**From:** Hill, Grace <Grace.Hill@e-lindsey.gov.uk>  
**Sent:** 22 January 2026 10:29  
**To:** Hill, Jess  
**Cc:** De-Ruyck, Chris (ELDC); \_planningadvice  
**Subject:** H09-1278-25 ecology comments

H09-1278-25 - Land East of Forest Way Holbeach Spalding Lincolnshire  
Proposed Erection of 2 Bungalows.

DRAWING NUMBER | LDC4657 - 11

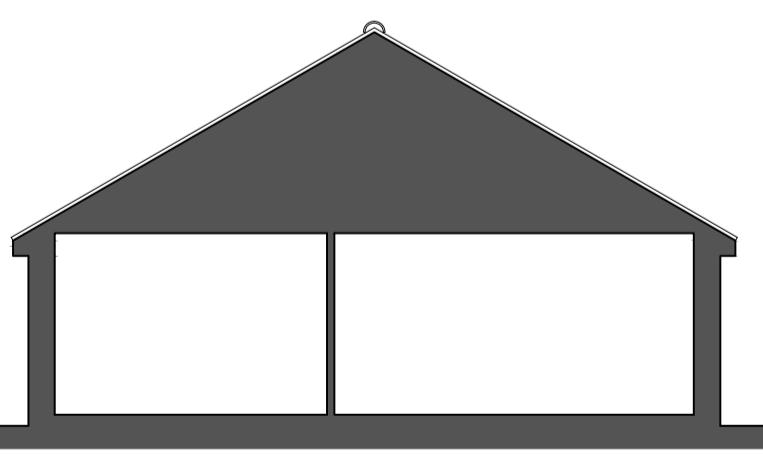
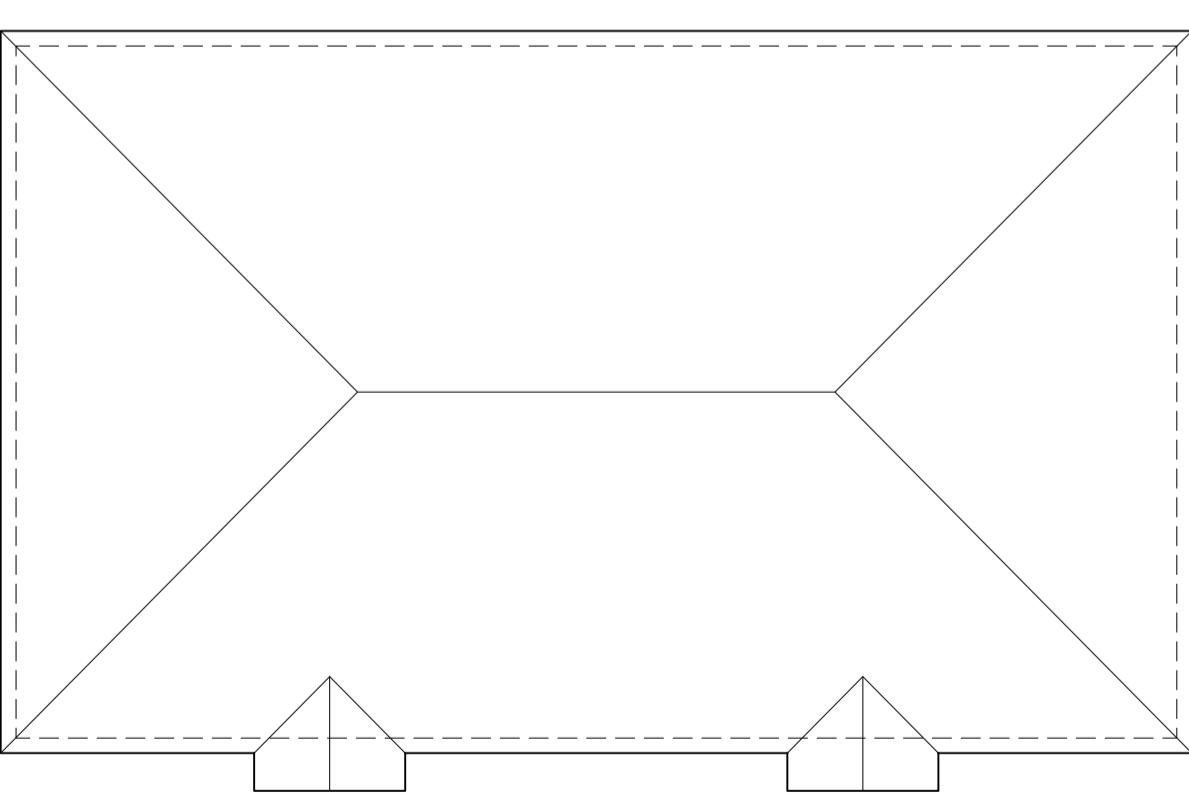
- We request that a total of 2 integrated universal nest bricks (e.g., S Brick, Swift Nesting Brick, Manthorpe, Swift Bricks: The 'Universal' Nest Brick – by Dick Newell | CIEEM) are incorporated into the external fabric of one or both buildings. These should be located at a height of 4+ m metres, on the north or east elevations to avoid overheating, and grouped colonially where possible, in accordance with best-practice guidance such as British Standard BS 42021:2022. The bricks must be installed during the construction phase and retained thereafter for the lifetime of the development.

- We also request that one integrated bat box (e.g., Integrated / Built-In Bat Boxes, Integrated Eco Bat Box | The Nestbox Company) are added to each dwelling. These are required to enhance biodiversity and to be in line with the local plan section 7.2.14.

PROJECT | Wignalls Wood, Wignalls Gate, Holbeach, Spalding, Lincs
DATE | December 2025
TITLE | Biodiversity Net Gain Plans
SCALE | As Shown
ORIGINAL SIZE | A1
DRG STATUS | PLANNING
DRAWING NUMBER | LDC4657 - 12

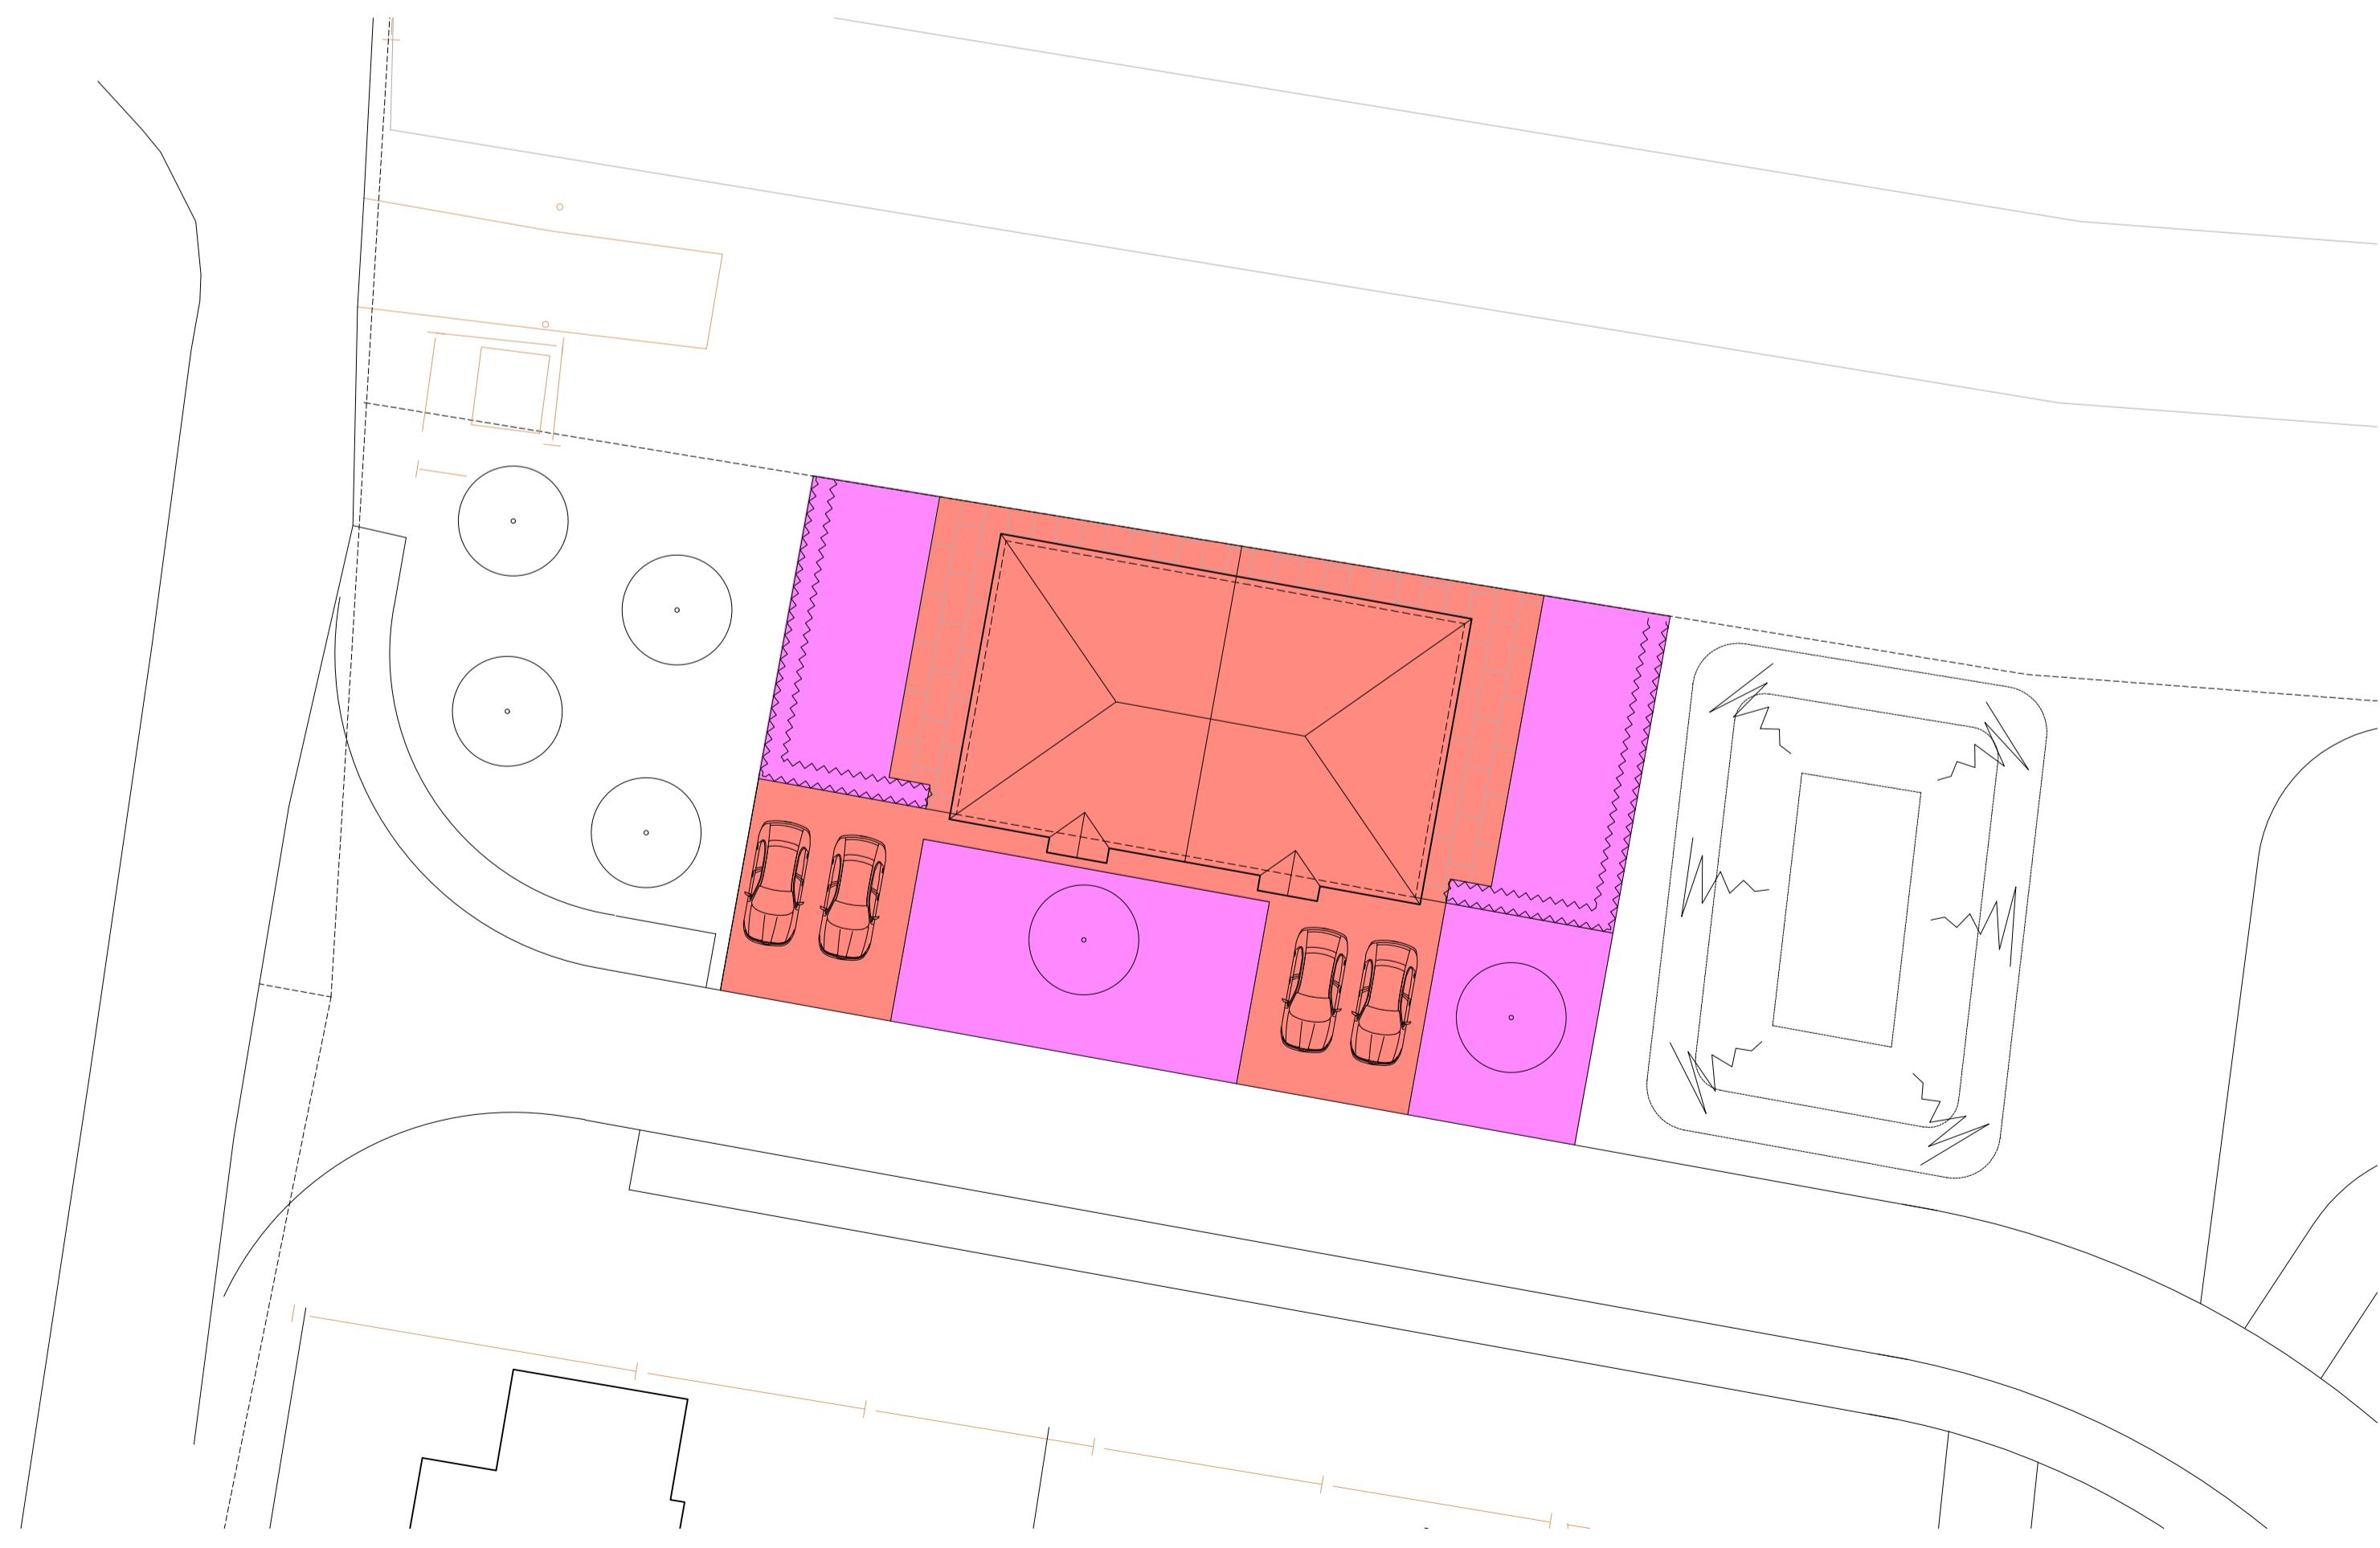
- Overall, the biodiversity assessment and metric calculations appear rigorous, and we can have confidence in their conclusions. In this case the metric indicates that 10% mandatory net gain cannot be achieved on-site, and therefore the proposals require 0.1808 area-habitat units off-site. These will need to be secured pre-commencement and can be achieved via 2 routes:

1. Bespoke habitat creation/enhancement could be undertaken by the applicants on land they own elsewhere or in agreement with another landowner. To discharge the biodiversity gain condition the applicants would have to secure the appropriate habitat creation/enhancement by either entering a section 106 agreement with the local authority or through undertaking a conservation covenant with a responsible body pre-commencement.

2. The applicants could purchase the appropriate number of units from an off-site habitat bank and evidence this to the authority pre-commencement. This can be achieved through the applicants contacting an off-site unit provider, aka a habitat bank, (which has biodiversity units registered on the national gain-site registry) to arrange a contract for the applicant to purchase the necessary units from the habitat bank. The habitat bank then notifies the national gain-site register to allocate the specifically referenced units to the applicant. To discharge the general biodiversity gain condition, the applicant provides us with this reference information and evidence of the purchase (e.g. a receipt or copy of the contract with the habitat bank) along with the biodiversity gain plan that they must submit to us pre-commencement. These details are also recorded within a finalized version of the metric submitted with the gain plan. The authority can then independently confirm the unit transfer by checking the unit references against the national gain-site register and then approve the gain plan to discharge the Biodiversity Gain condition.

- We will require a Biodiversity gain plan pre-commencement.
